The Drainage Engineer has made the following comments on the details submitted.

Condition 11- surface water drainage design

Application No: CM/2/21/DOC
Registered: 11th January 2021
Site Address: Scyld Horsemere Green Lane Climping BN17 5QZ
Description of Works: Approval of details reserved by condition imposed under CM/21/19/PL relating to conditions 10-schedule of materials & finishes; 11-proposed surface water drainage; 12-discharge of flows to watercourses or for the culverting, diversion, infilling or obstruction of any watercourse on or adjacent to site & 13-maintenance & management of surface water drainage system.

DRAINAGE GA

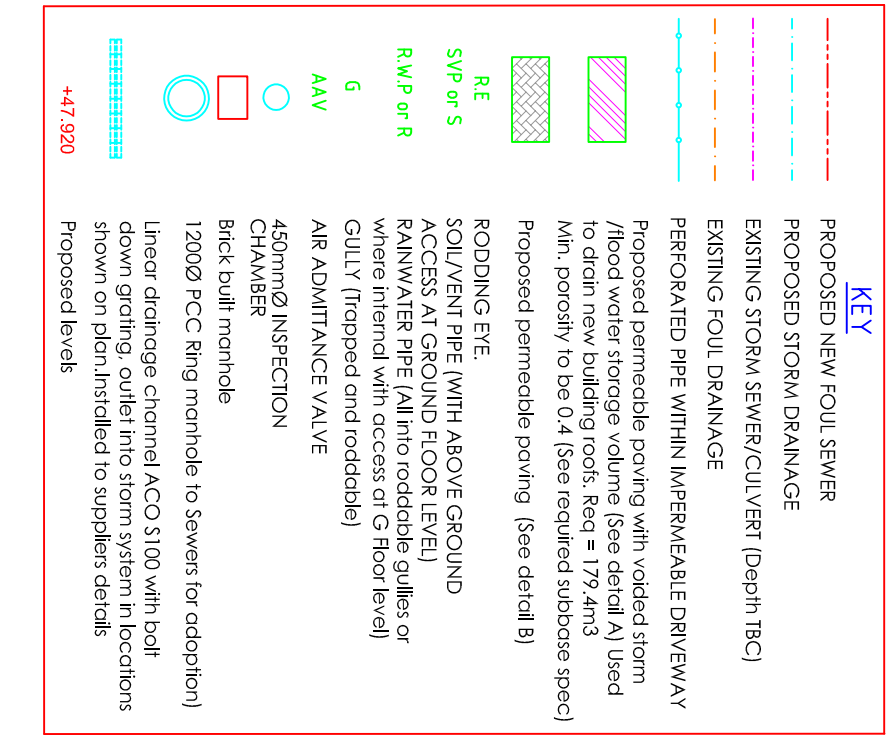
1. The calculations submitted use FSR rainfall and a cv of 0.75, please use Cv=1 or the latest FEH rainfall.
2. The invert level, and flow restriction of the hydrobrake are inconsistent between calculations and layouts. Please update to ensure consistency and include hydrobrake unit reference on surface water drainage layout and construction details.

3. Please ensure modelled slope of permeable paving is accurate.
4. Please detail finish and formation levels of permeable paving.
5. Please detail all pipe diameters and falls on plan.

6. A minimum of 300mm sump depth should be provided upstream of all connections into the permeable paving.
7. Where connections are being made to pipelines rather than direct to manholes – add note ‘all connections to be made using oblique 45 degree junctions’

8. Please indicate bed level of ditch upstream and downstream of proposed point of discharge, as well as at the point of discharge.
9. Please indicate invert level of outfall to ditch clearly. And update the position so this is accurate.

10. No connections are shown to/ from the permeable car park areas. Given the depth of groundwater these structures should be lined and have a positive means of drainage. Please ensure these areas are included within calculations and link to the road drainage.

STORM WATER DISCHARGE INTO PERMEABLE
PAVING SYSTEM DETAIL

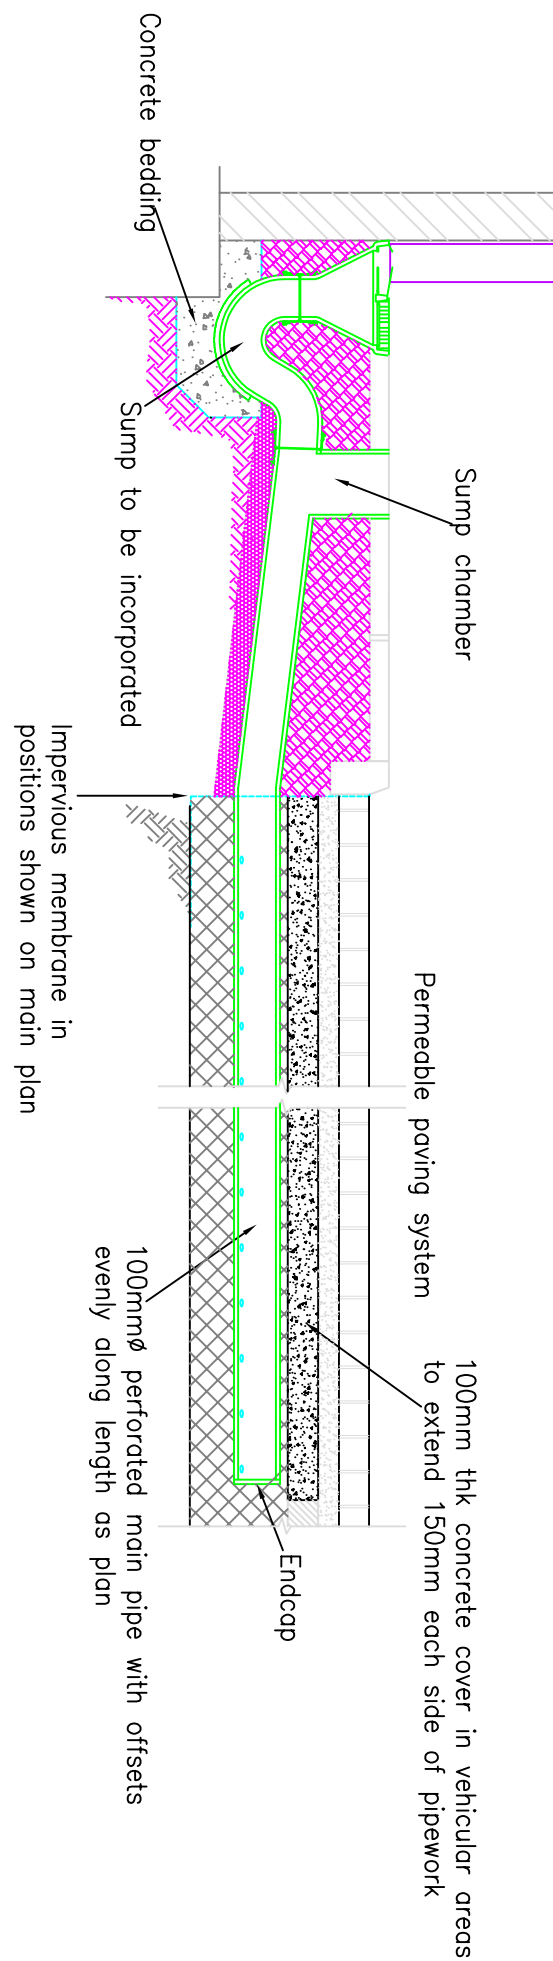
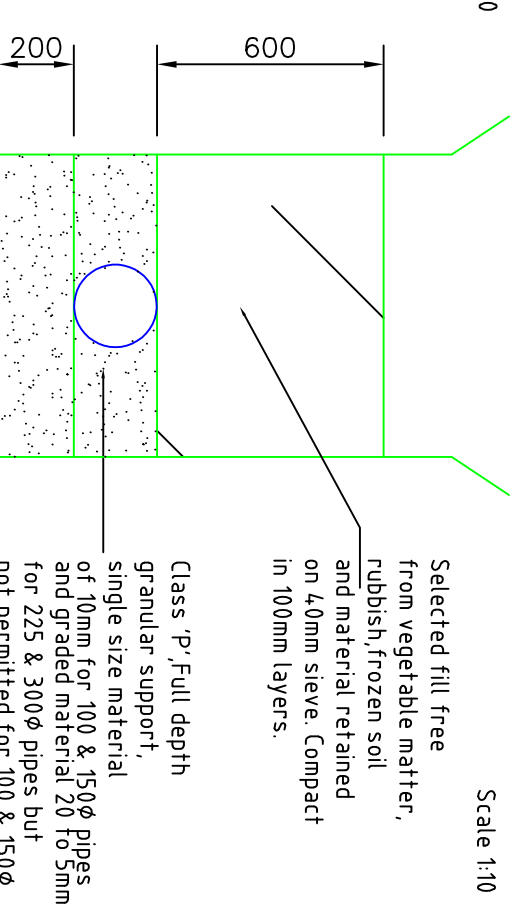
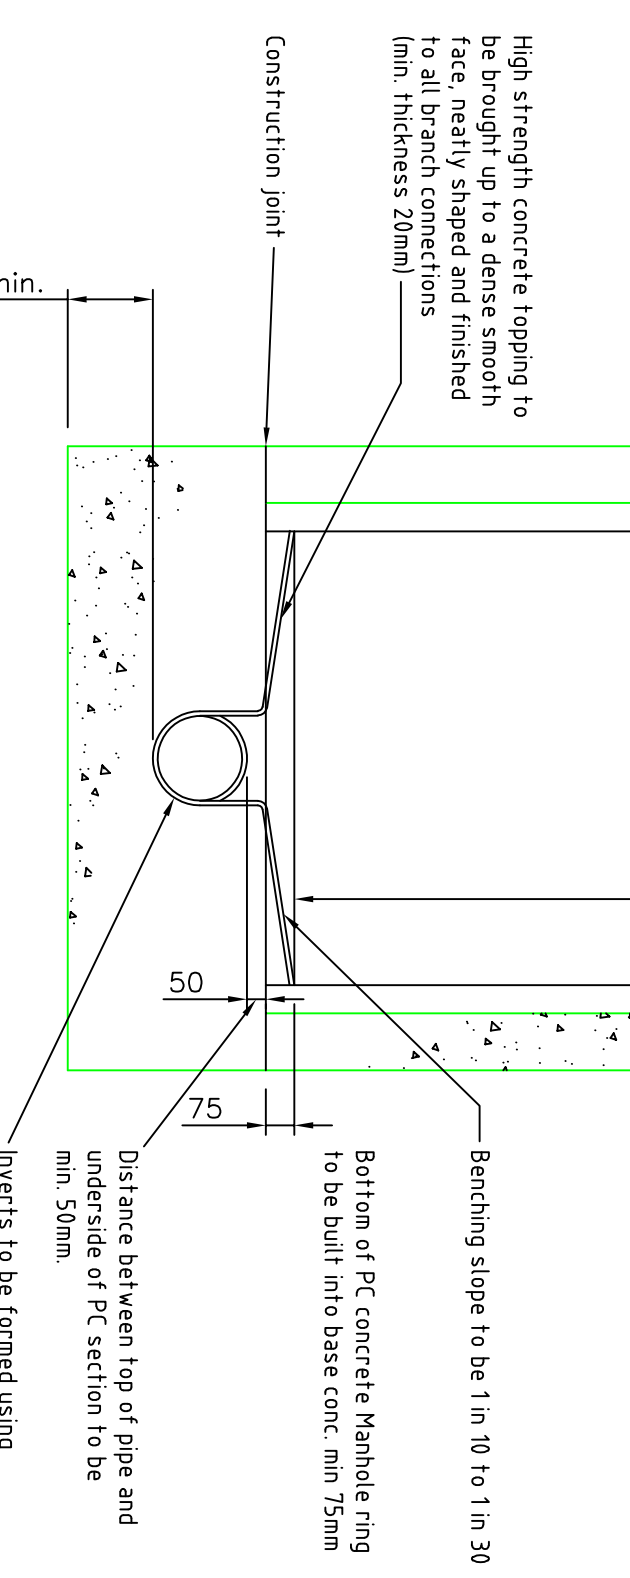
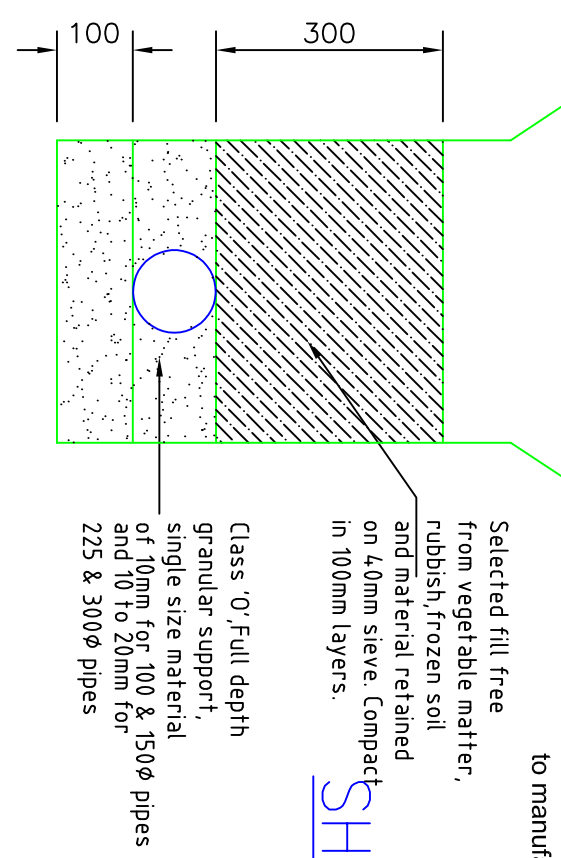
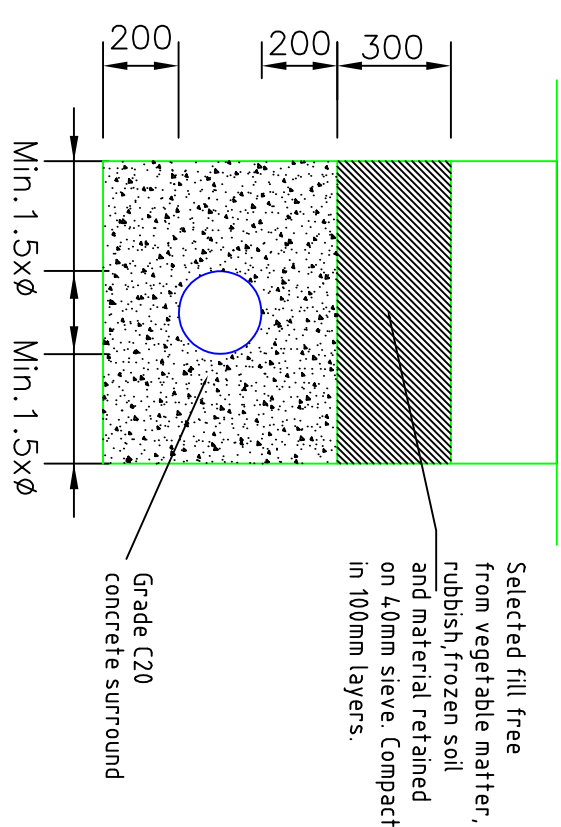
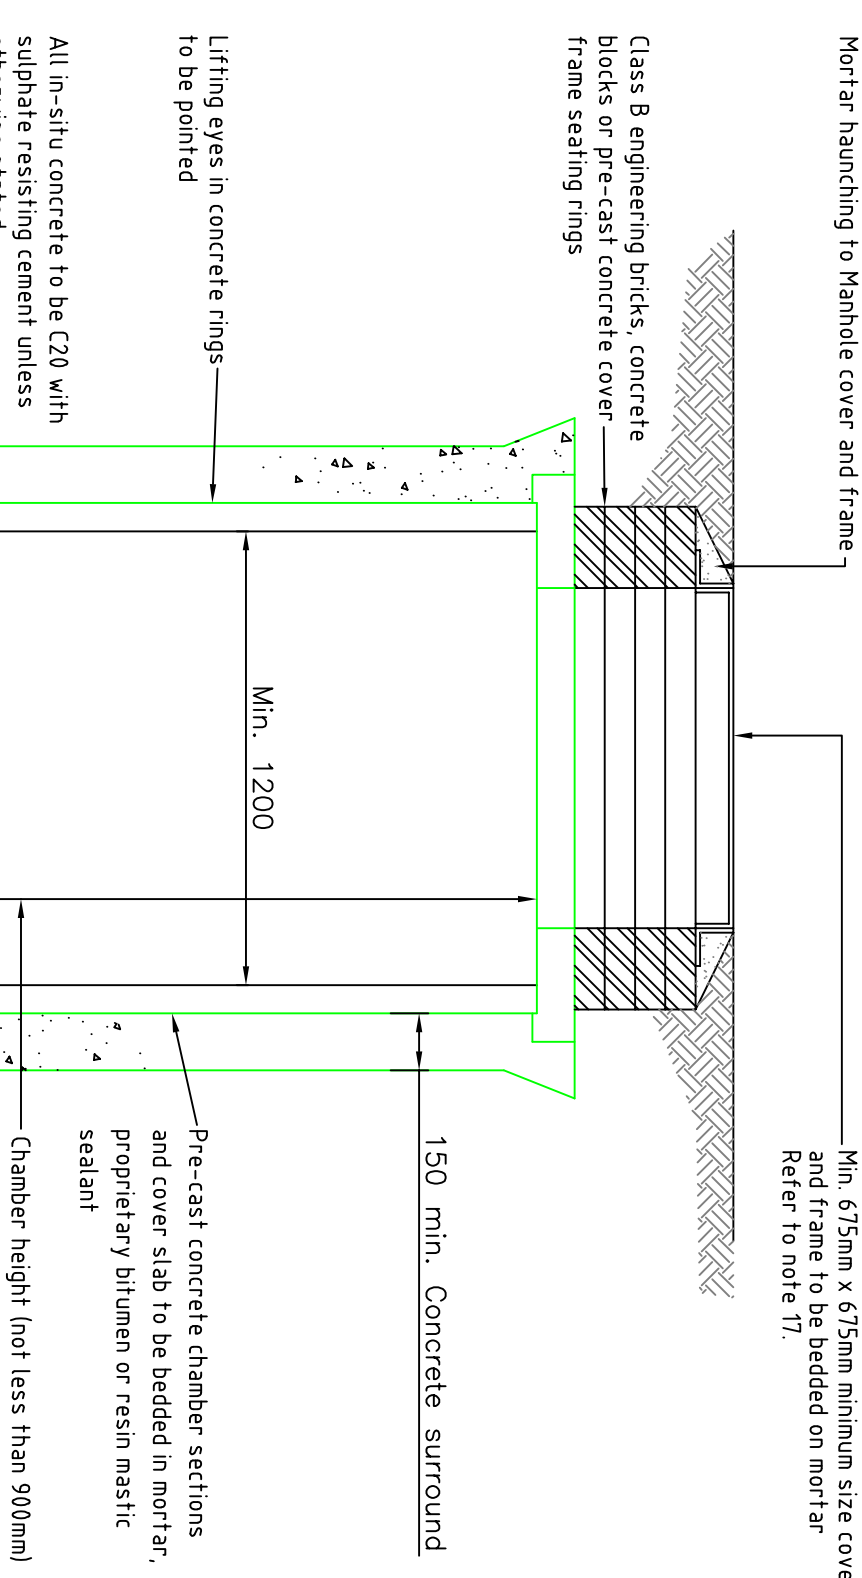
11. Please provide construction detail drawings of : hydrobrake (site specific); drainage channels, catchpits, and proposed headwall.
12. The permeable paving details must show an impermeable membrane around the side and base.

13. The permeable paving details must indicate minimum depth of sub-base and sub-base material.
14. I note that it is proposed to have a 100mm thick concrete cover slab over the top of the perforated main pipe, with 150mm each side of pipe work. This would have to be constructed very carefully so as not to cause concrete ingress into the perforated pipe, and it will also result in a strip of road being impermeable. Has the use of diffuser units been considered instead with a small fall in formation over the site? The outlet diffuser unit would have to be at the base of the sub-base. As should the pipe at the downstream end if this is to remain.
